PLANNING AMENDME NT

APPLICANT NAME AND ADDRESS BLM BUILDERS LTD DOUGLAS HORSESHOE ROAD SPADING Lincs PE11 3JA. Telephone:	AGENT NAME AND ADDRESS JULIAN NARRICK 8 BEECH GROVE EDNINGTON Lincs PE11 4XD Telephone: 07849 652067
SITE ADDRESS DETAILS REAR OF WAR MEMORIAL, SEAS END ROAD MOLLTON SEAS END, SPADING PE12 6LD.	
CURRENT APPLICATION NO: This amendment cannot be considered unless the relevant reference is stated.	H13-0507-24
Building Regulation reference relating to same development (if applicable)

FULL DESCRIPTION OF DEVELOPMENT OF CURRENT APPLICATION THAT THIS AMENDMENT RELATES TO	RESIDENTIAL DEVELOPMENT 2 DWELLINGS OUTLINE APPROVAL H13
--	---

J185-PL 17

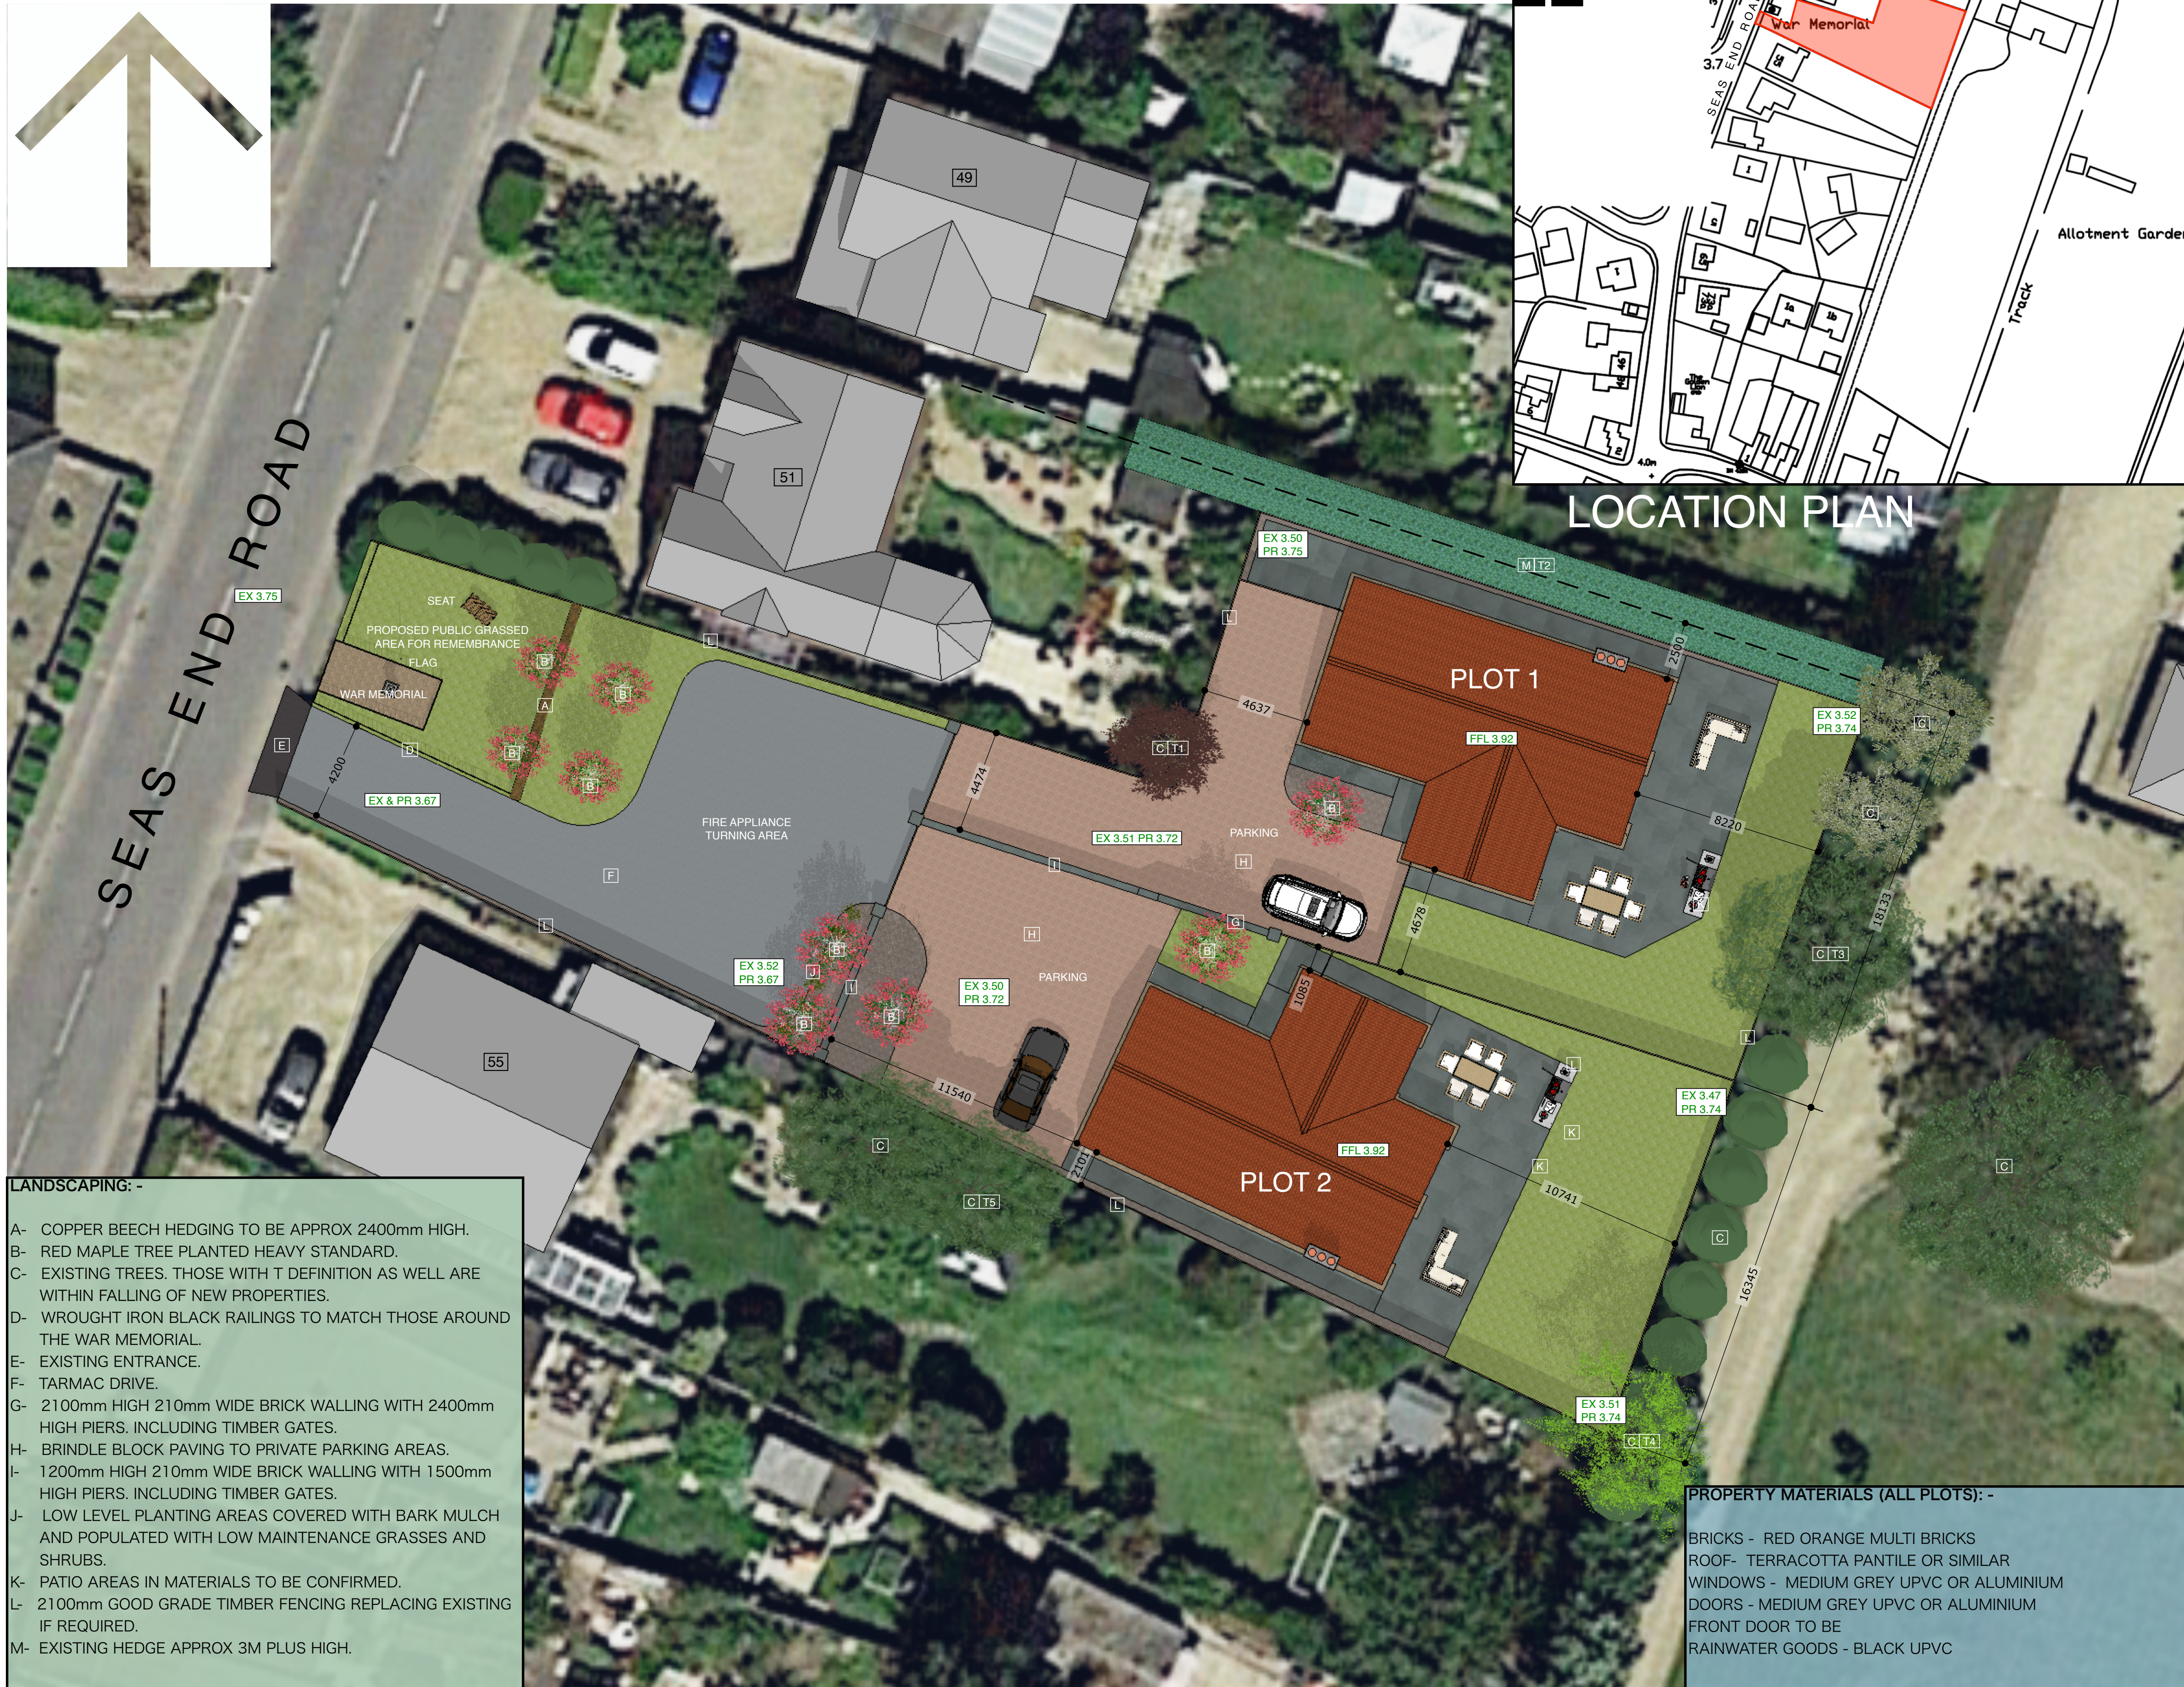
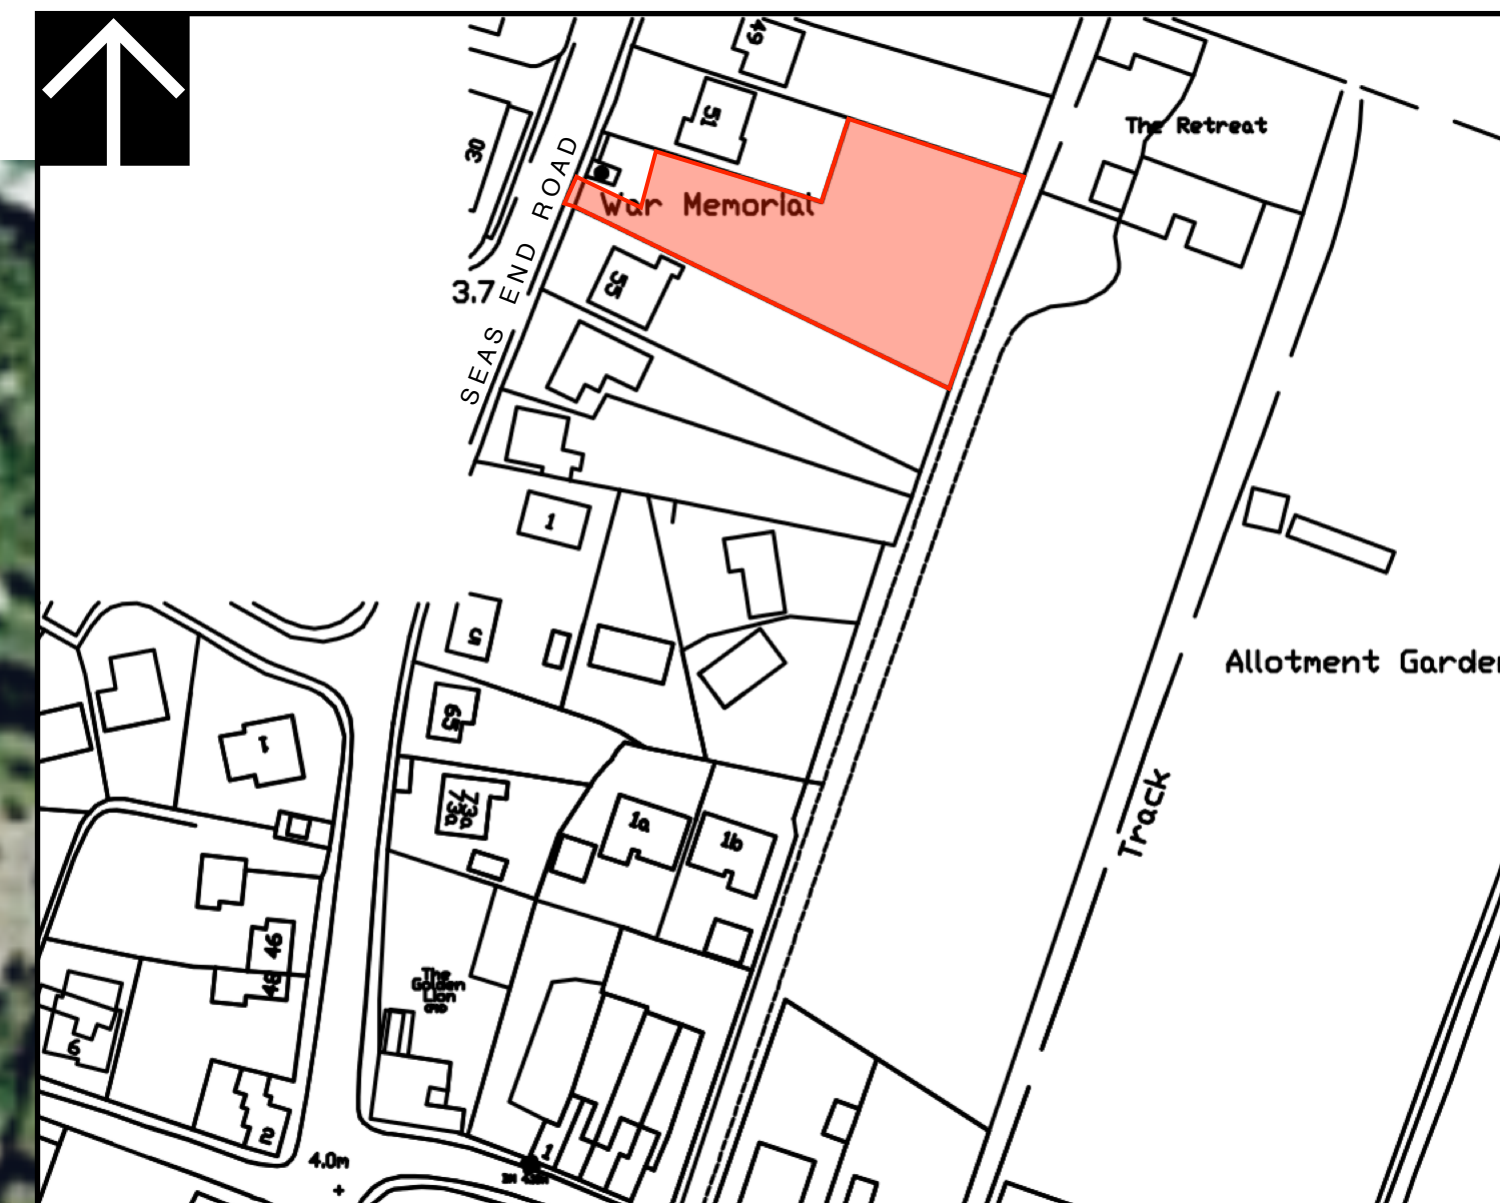
State details of amendments proposed. (Give a full detailed list of the changes, and also mark these clearly on the accompanying plans. Only the changes listed here will be considered)	BOTH DESIGNS REDUCED IN SIZE. USE SAME DESIGN HANDED.	
State drawing numbers of the current submission	J185-PL12, PL13, PL14, PL15 & PL16.	
Has this amendment been requested by the Council? (If so, state Officer dealing with the application)	YES/ NO	CARRIE, NIE SUTTON.
Describe any part of the original development which is excluded by virtue of the amendment, and state any alteration to plot numbers		
Has a similar amendment been submitted under Building Regulations? (If so, state Building Control Surveyor dealing with application)	YES / NO
